From: Barber, Robert [REDACTED]
Sent: 26 August 2016 15:28
To: Thomas Callaway; Goodwill, Stuart
Cc: Reimnitz-Wood, Jordan; David Innes; Paul Cann; Claire Potts
Subject: RE: *Ext: RE: FP/102/16/PL and FP/95/16/DOC

Please could we have further information on the following points to assist with the discharge of conditions application FP/95/16/DOC consultation (relating to submitted Drainage Layout drawing no. 5151:01):

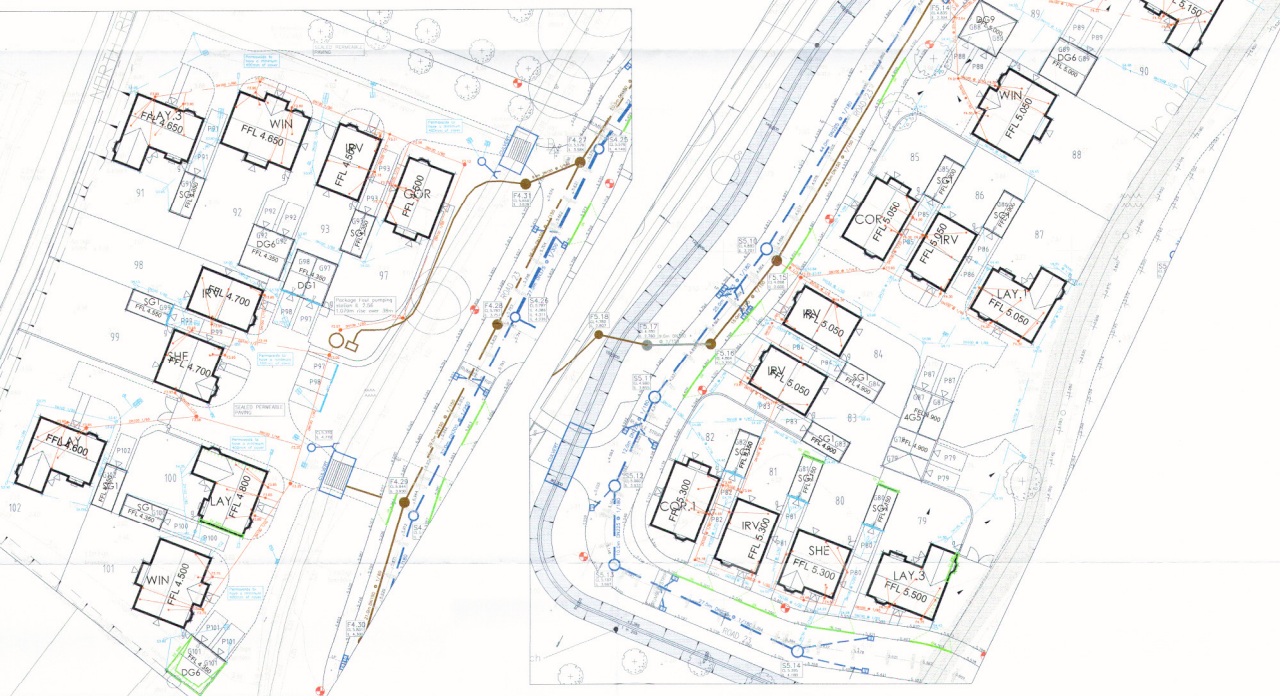
- Additional discharge points to ditches:
 - Tanked permeable paving has two unrestricted discharge points
 - Tanked crate system restricted to 5 l/s
 - Is there to be a change in discharge rate for the ponds as these ditches may not enter the main ponds?

- Is the ditch flowing towards the south (tanked crates outlet headwall is angled to the south, but it is not clear where the ditch discharges to in this direction)

- Is the tanked crate system at risk of flotation by high groundwater?
 - Is the change from draining all parts of the site to the main ponds due to levels and why was this not picked up earlier?

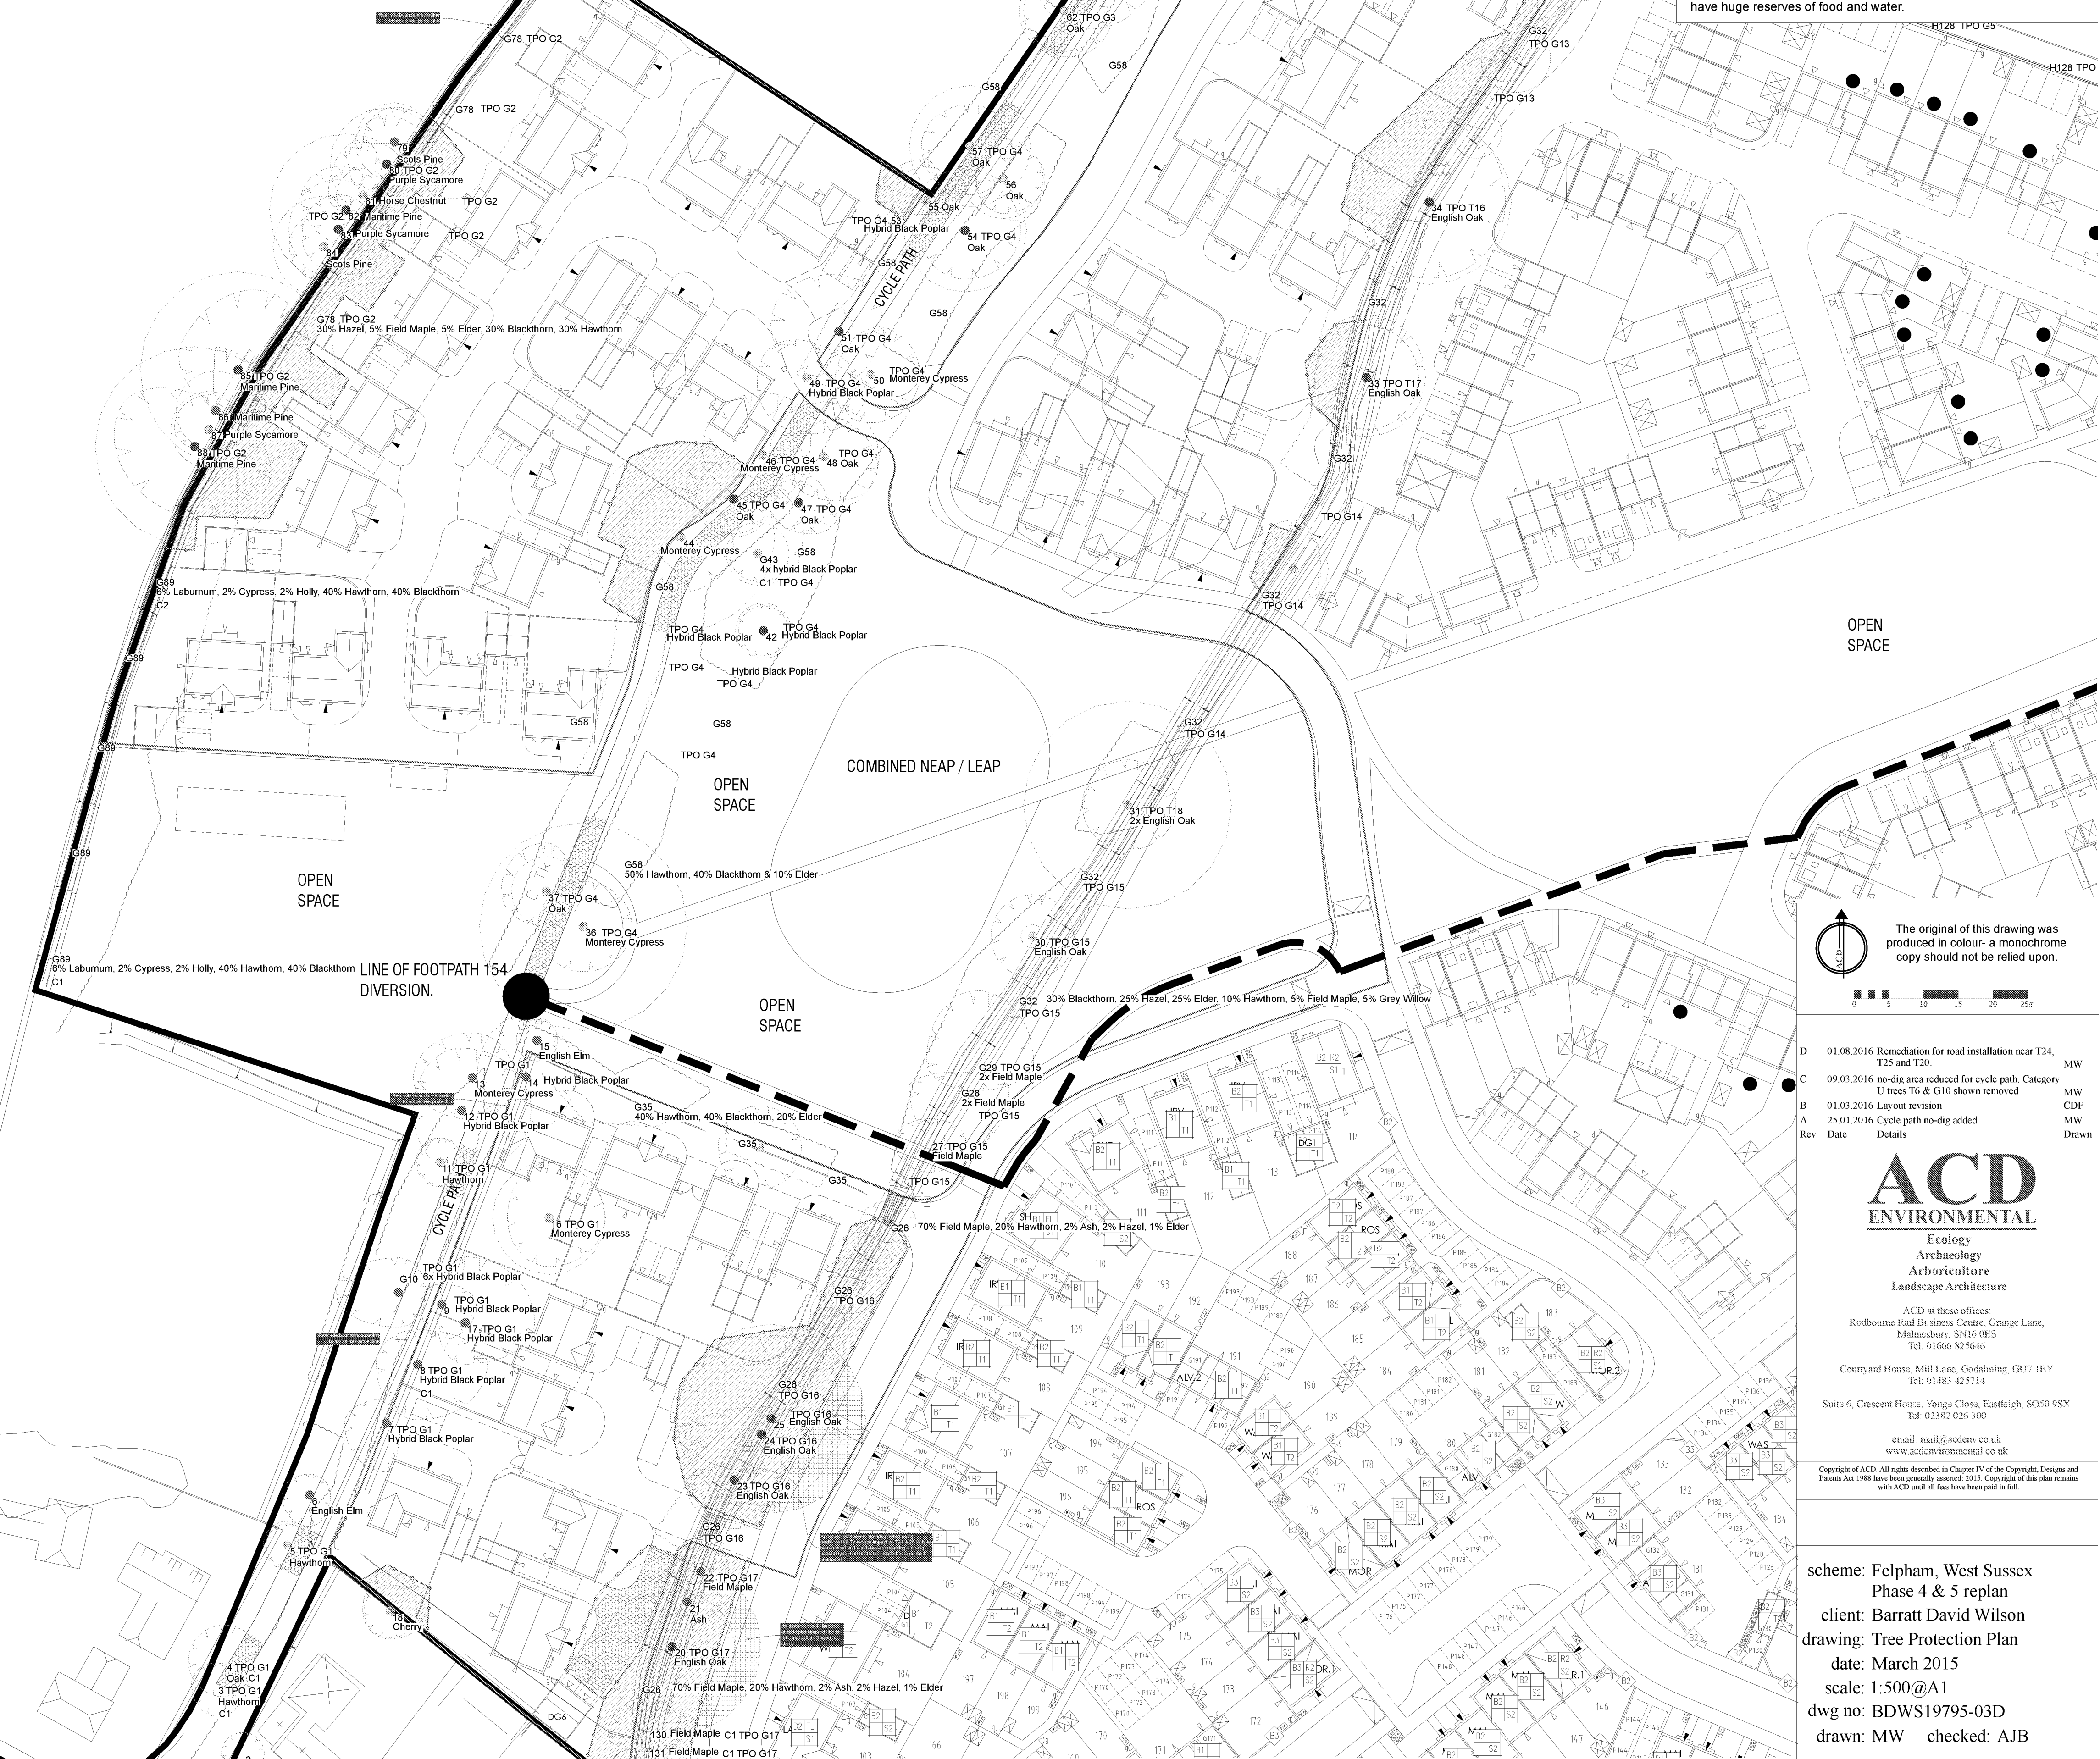
- Other:
 - Have Southern Water been consulted on the increased need for foul pumping stations?
 - Are any other drainage features affecting protected trees?

I have also spoken to our drainage engineers about the above DOC application relation to FP/55/15/PL. They still have concerns about the drainage proposed on site and about work continuing without these issues being agreed. There seems to have been a shift in the drainage scheme from everything draining into the main SUDS ponds in earlier schemes (e.g. FP/205/10 – the drainage condition was refused and not discharged on this permission anyway) and this scheme, which has its own drainage features. I will ask Paul Cann and Tom to let David know what their comments are so David can then pass them on. It's likely that further supporting information will be required in order to show that the scheme will work and that it works together with and doesn't negatively impact on the wider scheme. There also appears to be a foul drain passing through protected tree areas.
